Prepared for:
Macquarie University
Date:
25 September 2018

Response to Submissions

Macquarie University Central Courtyard Precinct

Figure 2 Comparison of previous and proposed skylight and sunlight penetration

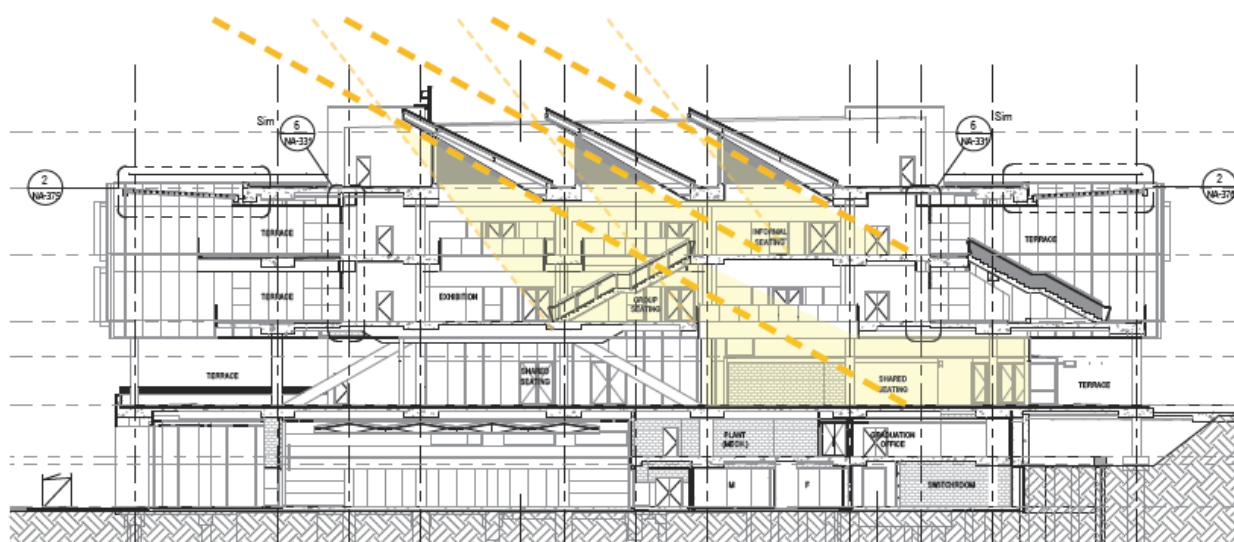
The proposed 1CC building brings additional natural light through an internal atrium but as the floor openings are not aligned the spatial impact of the atrium is compromised - as is the capacity to bring natural light into the building.

Subsequent to the SSDA submission design changes have been made. A large skylight has been designed with a northern orientation and angled to permit greater natural light penetration to the teaching levels. Interactions between the L01-L02 Learning & Teaching floors are facilitated via connecting stair voids. The spatial connection between Ground Level (food and beverage) and the Learning and Teaching levels is staggered to provide necessary acoustic separation.

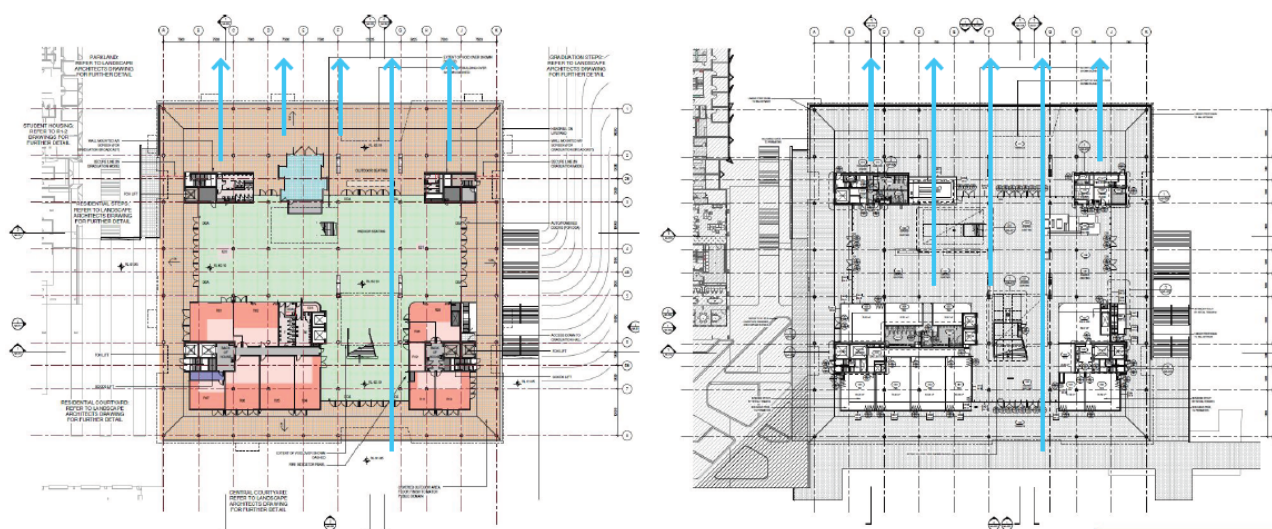
The ground level of the 1CC building is intended to open to the panoramic views north of the Academic Core. This view is obscured by the placement of stairs, lifts, amenities and a teaching area along most of the northern frontage. These could be reconfigured to capture a greater proportion of the view from within the building.

Teaching space has been removed from the Ground Level and increased transparency to northern parkland has been achieved. The U-Bar can be looked across. There are uninterrupted views from the terrace to the landscape.

We have studied the potential to reconfigure the ground level arrangement of the stairs, lifts, amenities and teaching areas to open up the view to the north from within the building however given the multiple competing functional and technical aspects it is assessed not be a viable option. The vertical stacking of services and egress routes associated these cores cannot be acceptably redesigned to open up one level of elevation of the five levels without causing significant impact upon those other levels.
